<b>Application Ref:</b>	3/2021/0274	 Ribble Valley Borough Council <a href="http://www.ribblevalley.gov.uk">www.ribblevalley.gov.uk</a>
<b>Date Inspected:</b>	~	
<b>Officer:</b>	AB	
<b>DELEGATED ITEM FILE REPORT:</b>		<b>REFUSED</b>

<b>Development Description:</b>	Proposed one agricultural building - in lieu of approval 3/2020/0364 which will not be built.
<b>Site Address/Location:</b>	Greenbanks Farm Green Lane Grindleton Road Grindleton BB7 4QJ

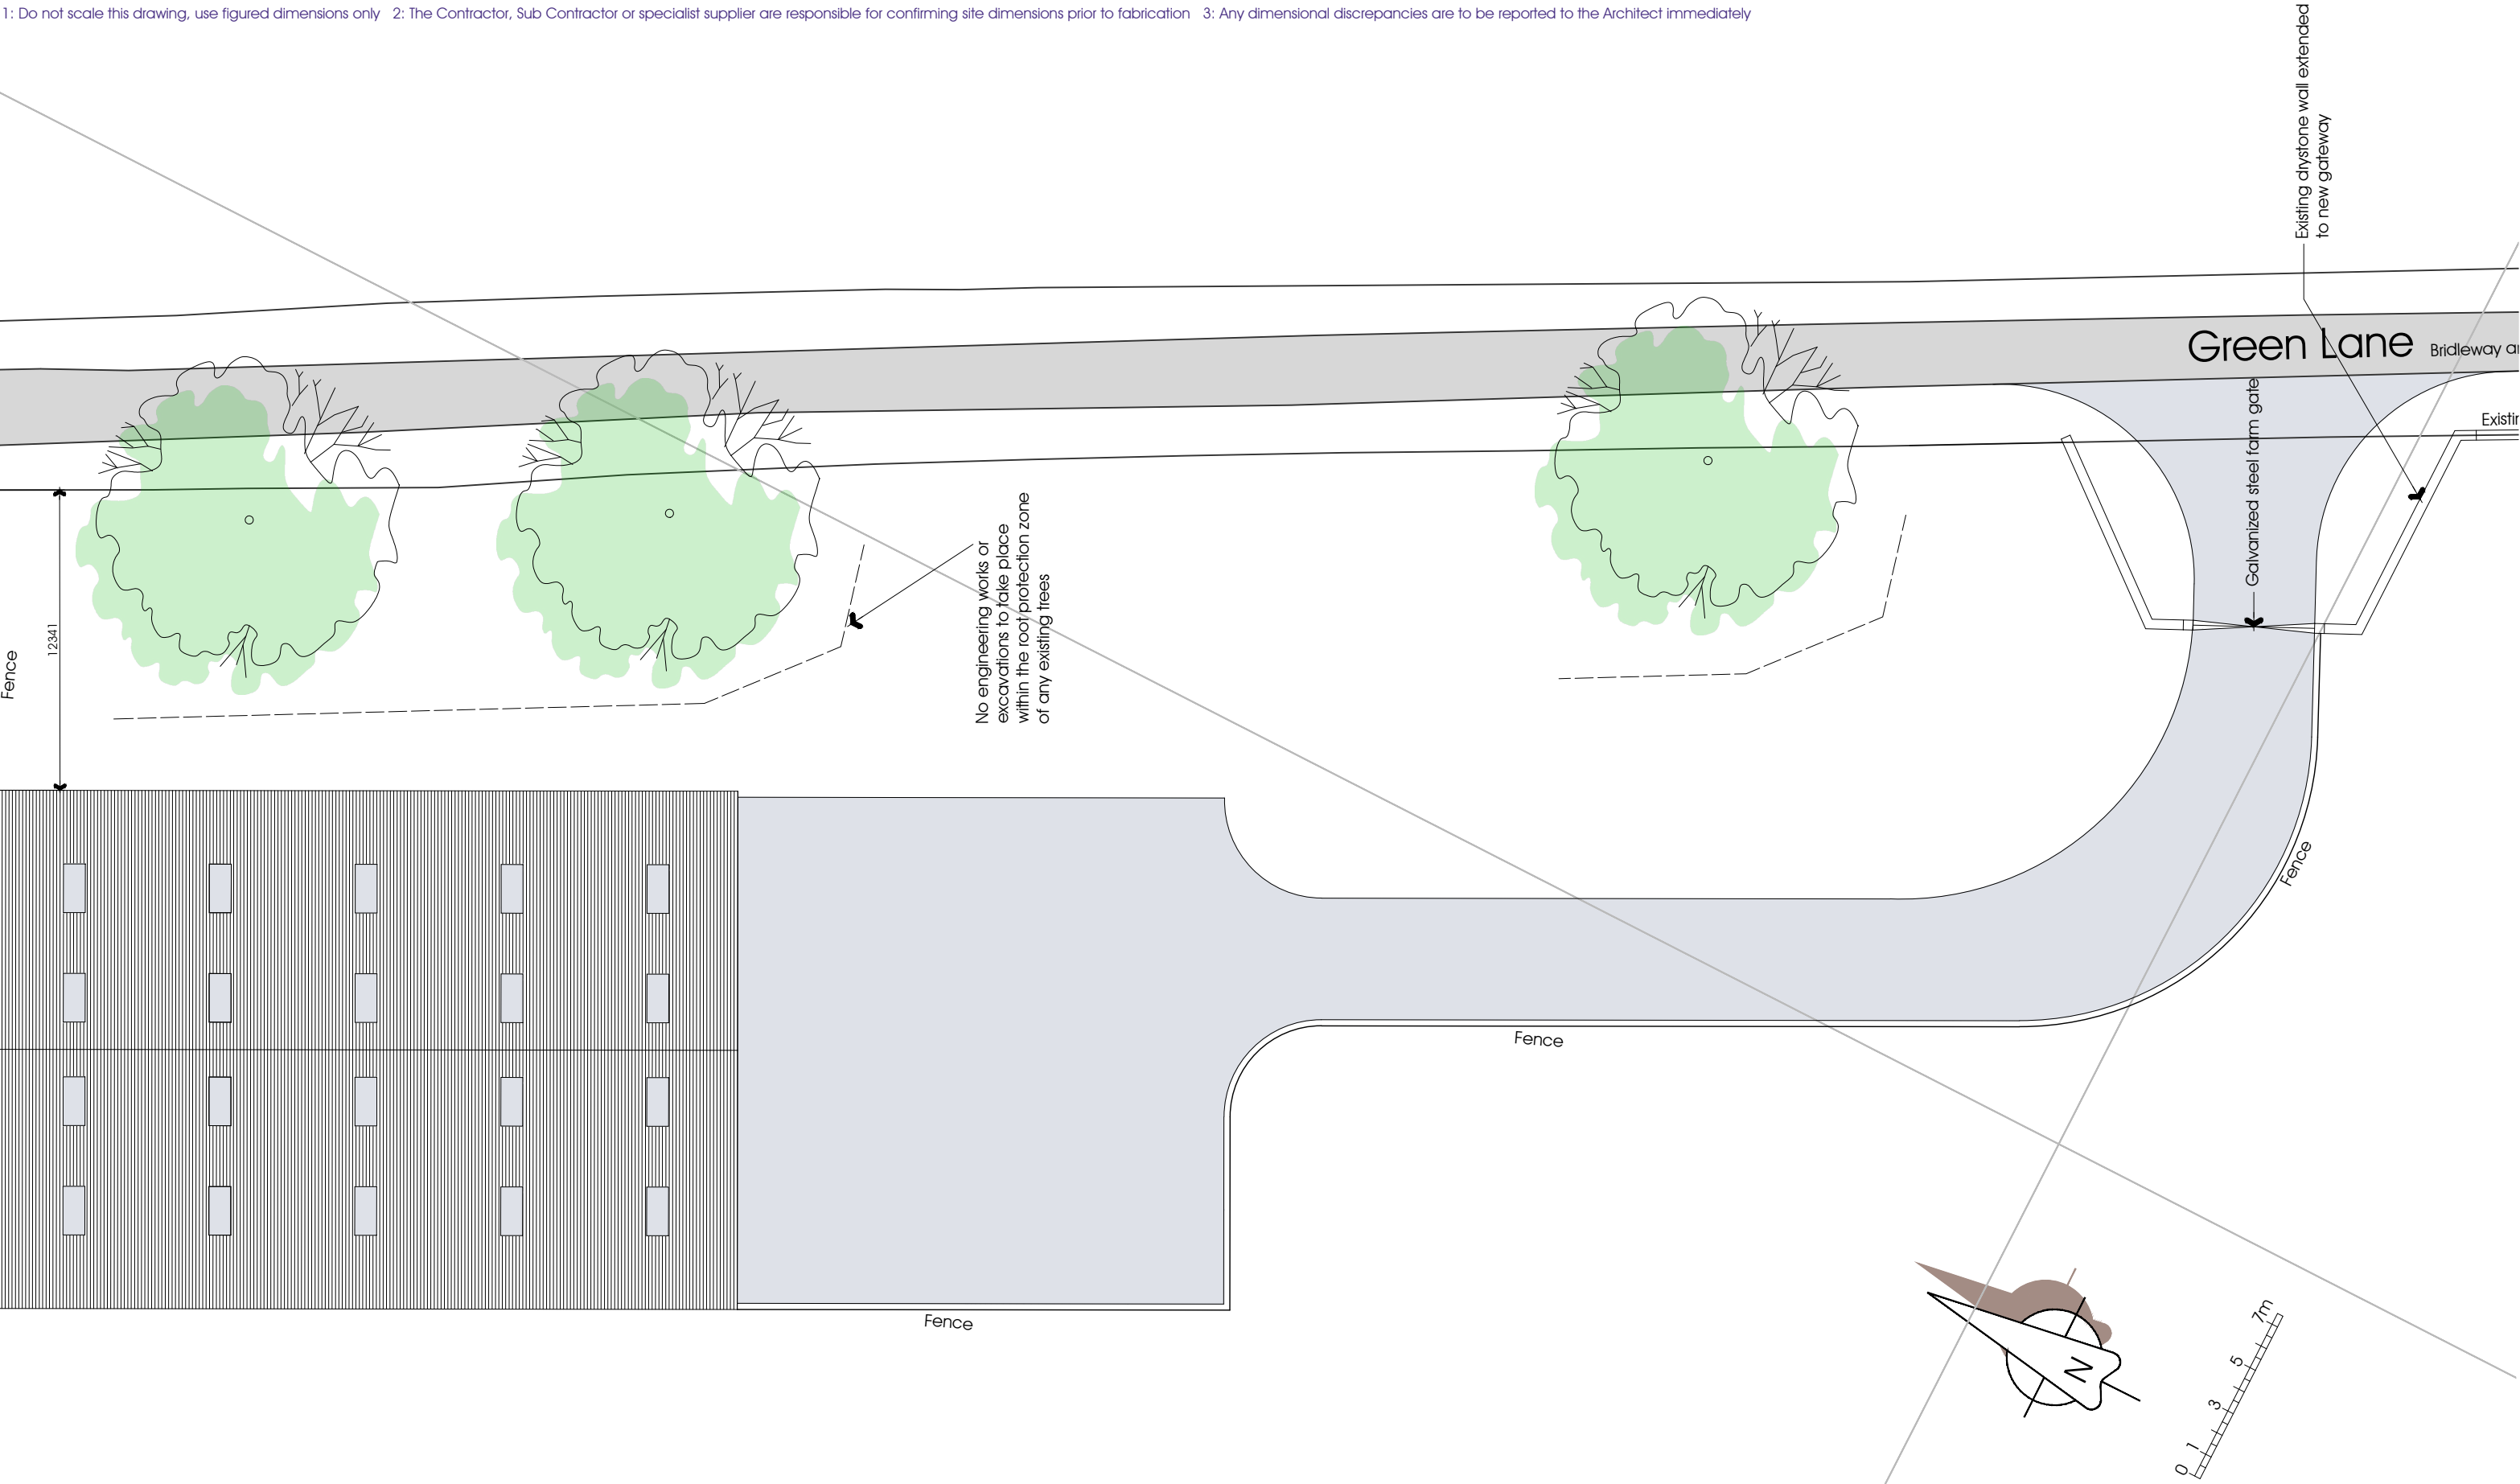
The ground area of the development comprising the proposed building and hardstanding area denoted on the submitted plans would exceed 1,000 square metres, calculated as described in paragraph D.1(2)(a) of Part 6.

The development also would include the erection of a building to be used for the accommodation of livestock within 400 metres of the curtilage of a protected building, Greenbank Cottage.
